LSC Responses to TIS Redline Comments

Falcon Meadows at Bent Grass Filing No. 3 Transportation memorandum (LSC #S214332) April 15, 2022

PCD File No
SF2216

Figure 2
Site Plan

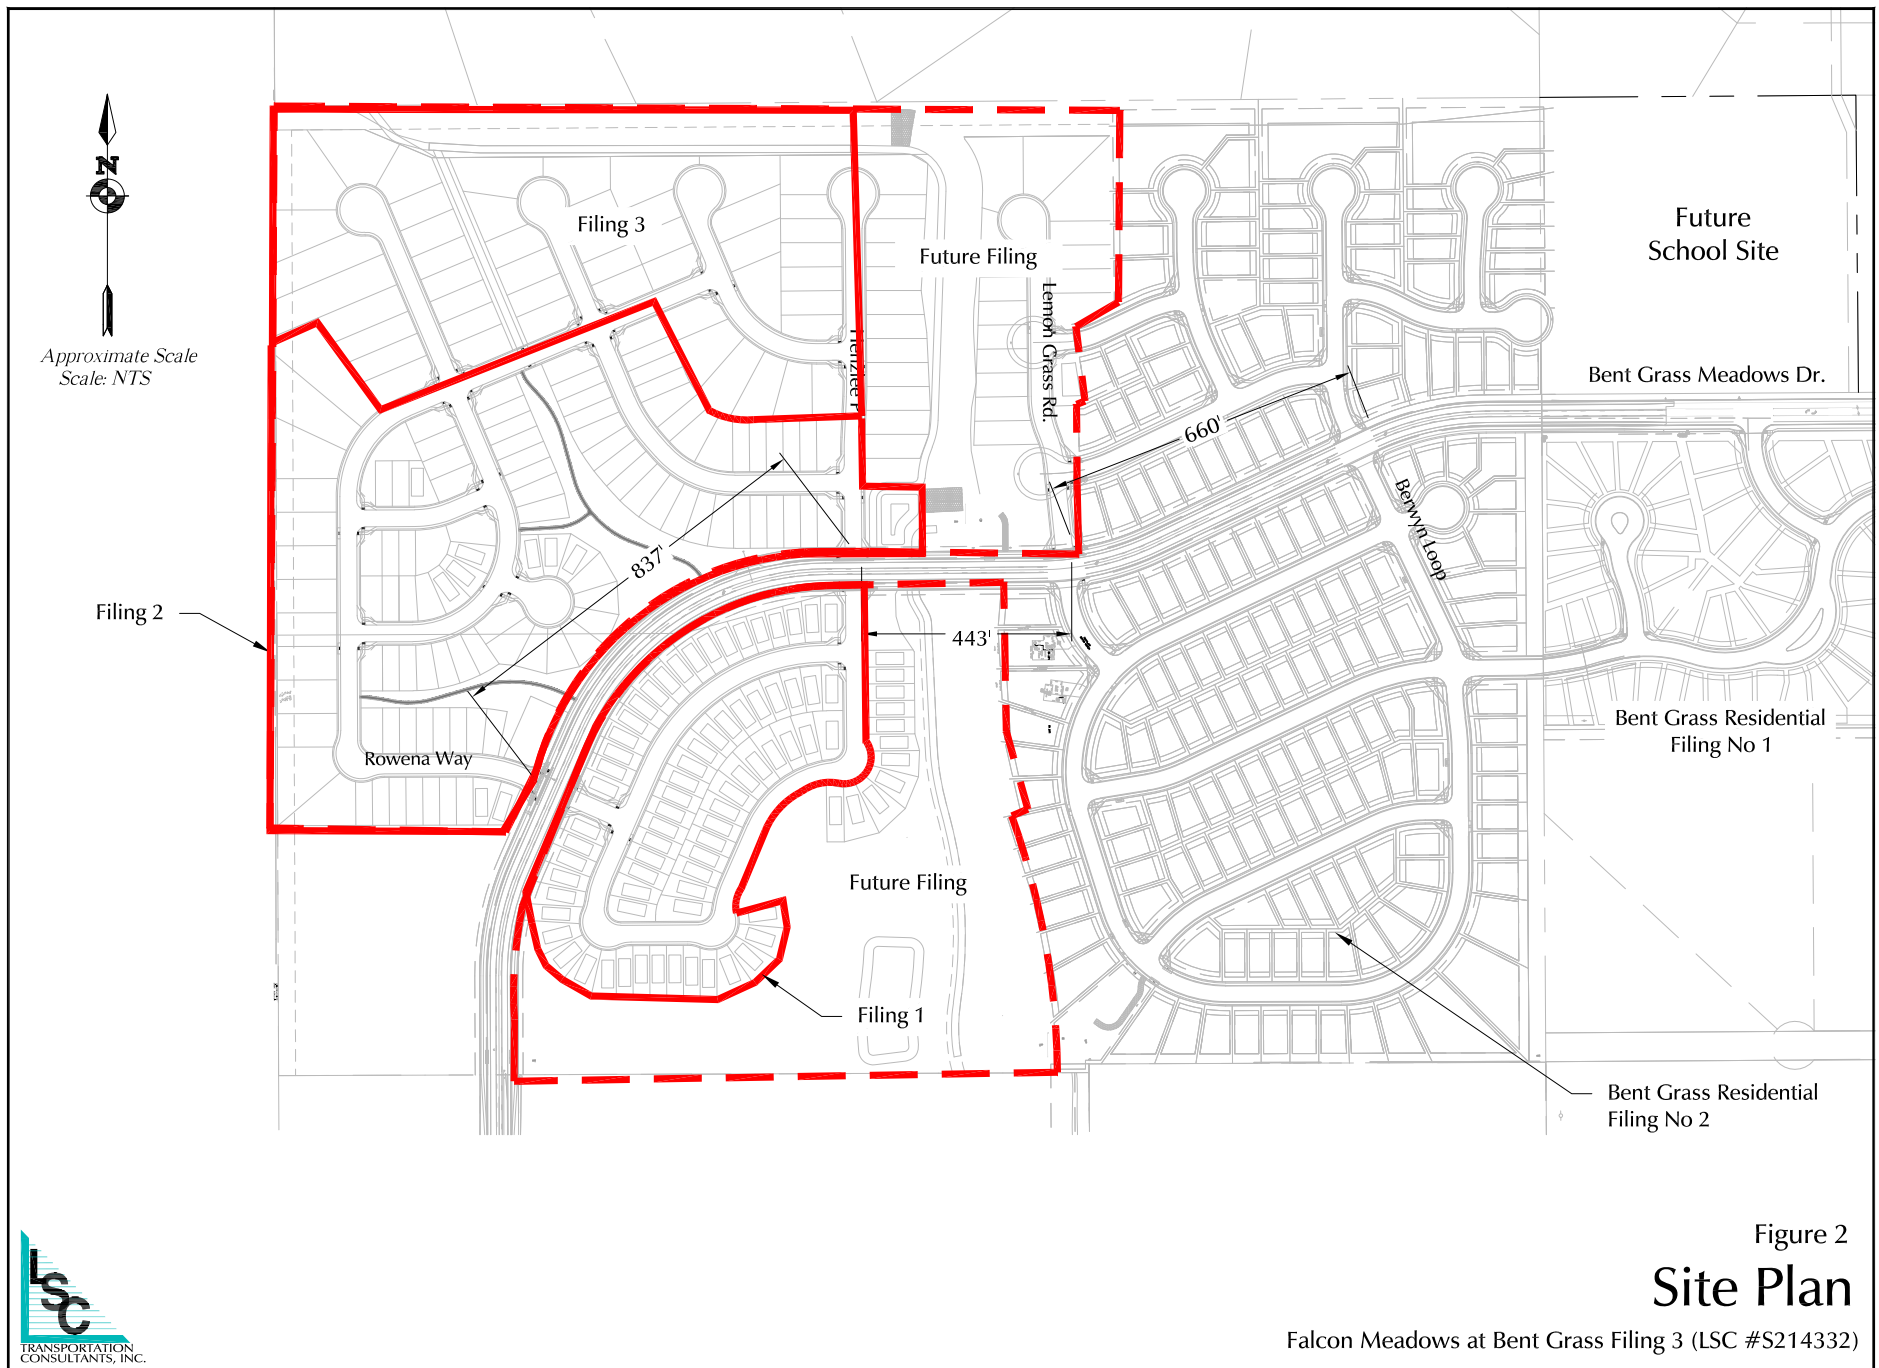
The two access points to Bent Grass Meadows Drive are part of Filing 2. Please revise the narrative to reflect that.

↩ Author: kdferrin Subject: Sticky Note Date: 6/24/2022 11:42:47 AM
LSC Response: Revised as requested
